REGULATION 4 OF THE INFRASTRUCTURE PLANNING (CHANGES TO, AND REVOCATION OF, DEVELOPMENT CONSENT ORDERS) REGULATIONS 2011 APPLICATION TO MAKE A NON-MATERIAL CHANGE TO THE OAKLANDS FARM SOLAR PARK ORDER 2025 (SI 2025/739) AS CORRECTED BY THE OAKLANDS FARM SOLAR PARK (CORRECTION) ORDER 2025 (SI 2025/1070)

EN010122 – Oaklands Farm Solar Project Non-Material Change Application.

Amy Wheelton Independent Seales South Derbyshire District and Linton Division
Derbyshire County Councillor

Figure 4.11: Indicative Access Track  
Cross Sections (4.5m/6m/3.5m)

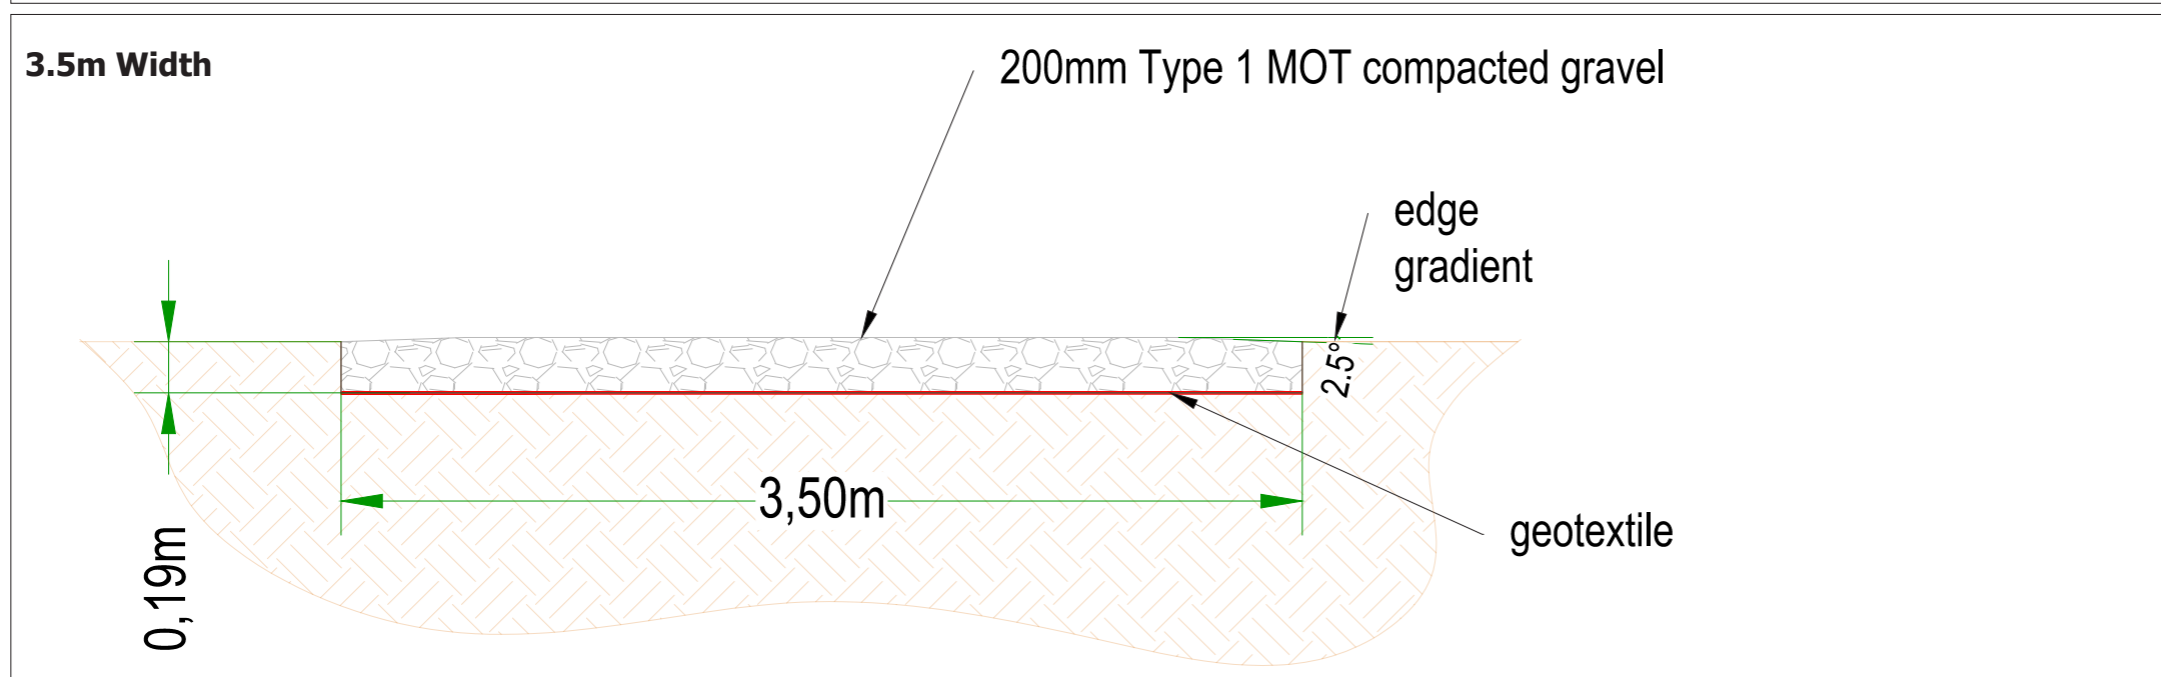
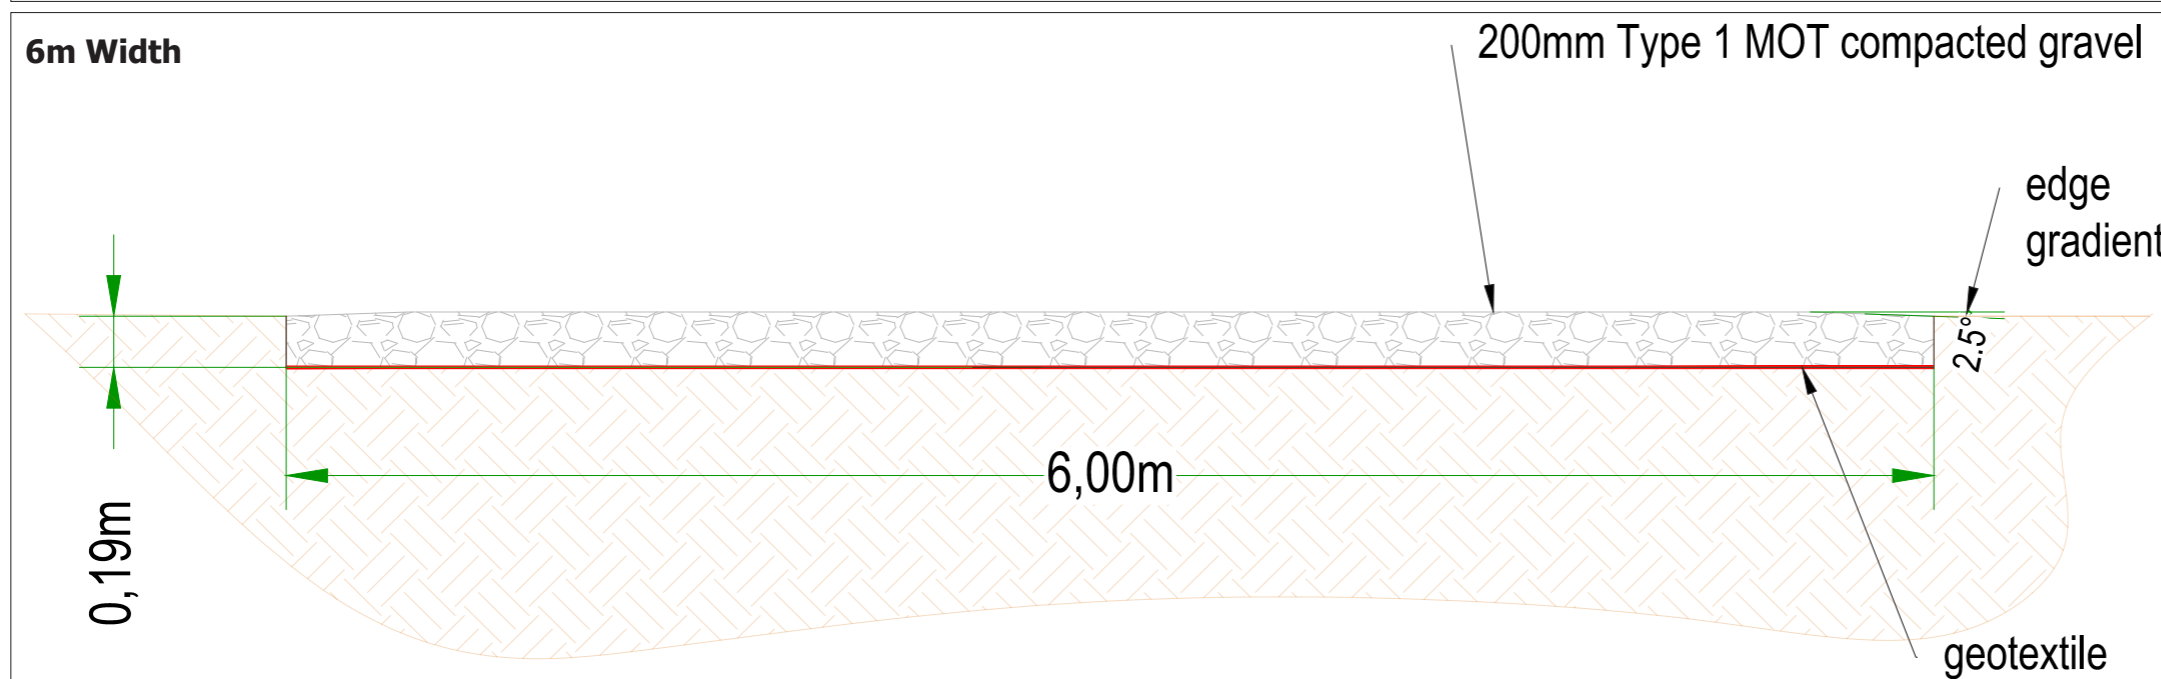
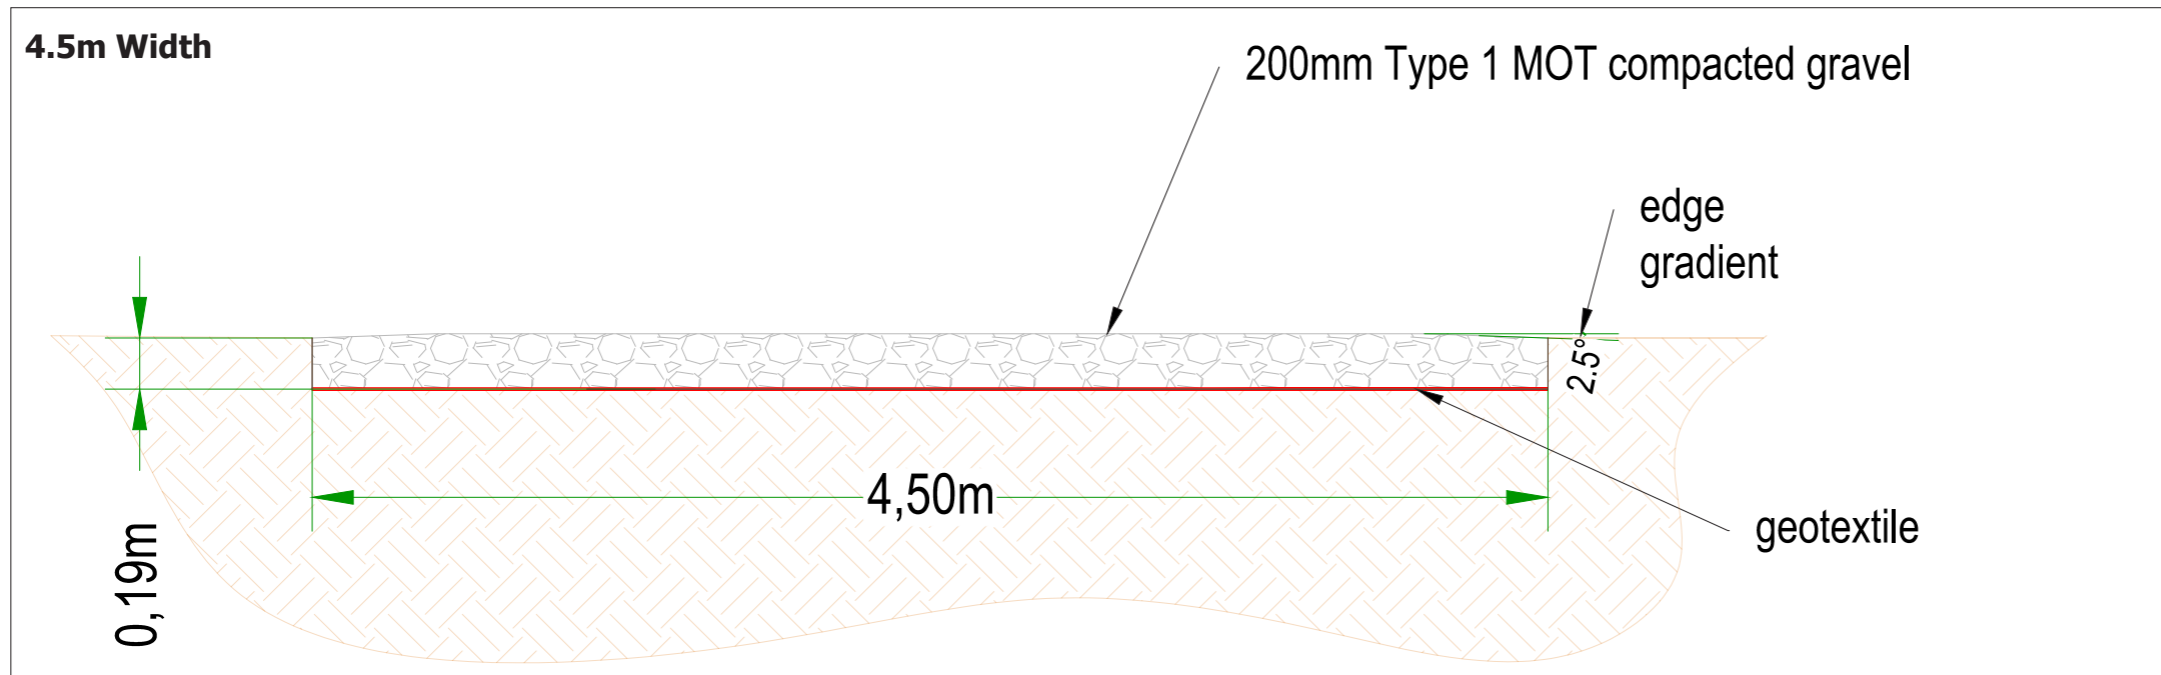
Phase 1 Haul Road - The drainage solutions offered are inadequate and in direct opposition to the professional guidance provided by the Geotechnical Surveyors (contained in DMOT/2026/0620) which states 8.3.3 that infiltration drainage is not recommended as none of the infiltration tests were effective due to ground conditions. The use of drainage swales will need to be reconsidered. Rosliston road clearly floods most of the winter.

Drawing Title	<b>SuDS Schematic</b>	Scale	<b>NTS</b>
	Drawing Number	-	Revision	<b>0</b>
	Project Name	<b>Oaklands Solar Farm</b>	Drawn by	<b>JEM</b>
	Project Number	<b>P20209</b>	Checked by	-
	Client	<b>BayWa</b>	Notes	© Crown copyright 2023 OS 100062269

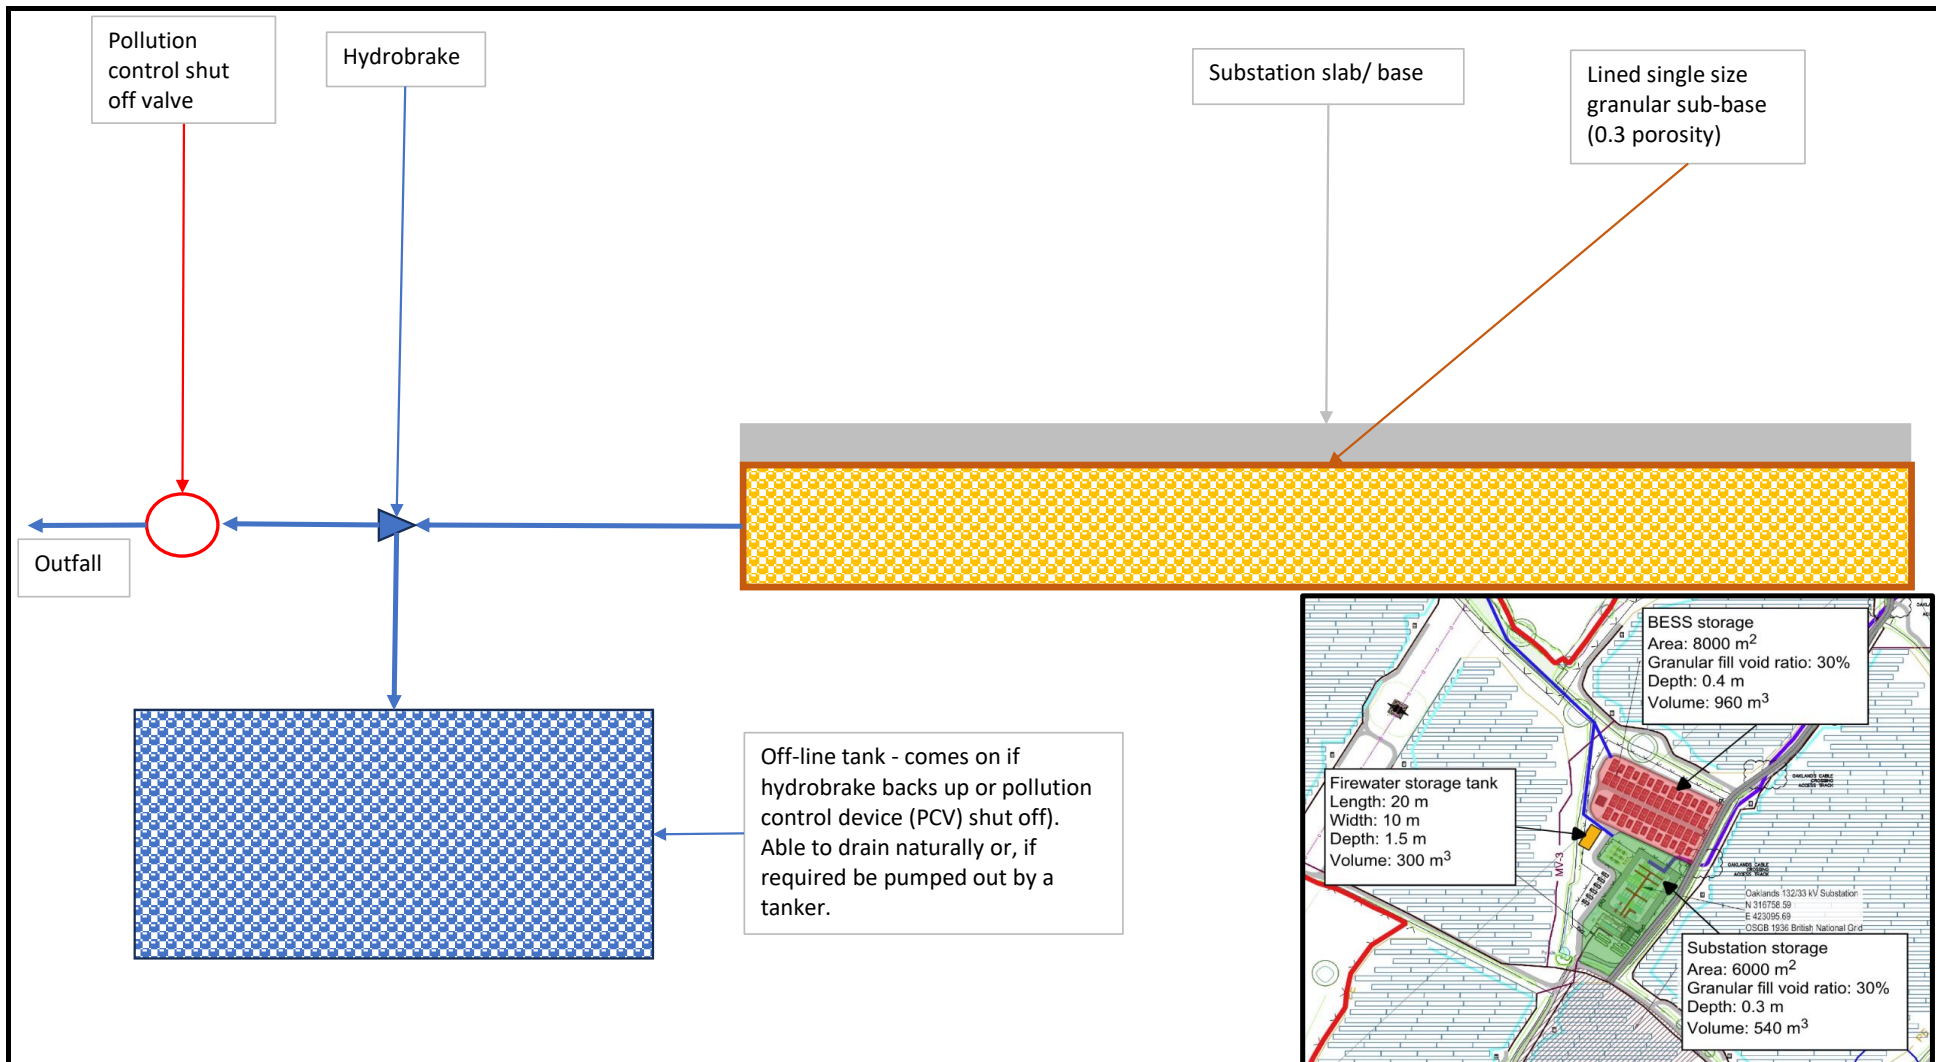
Phase 3. Internal access roads – see above, again – infiltration is the proposed drainage strategy, but this has been professionally determined to be an inadequate solution due to ground conditions. A new, more effective proposal is therefore required. Rosliston road clearly floods most of the winter.
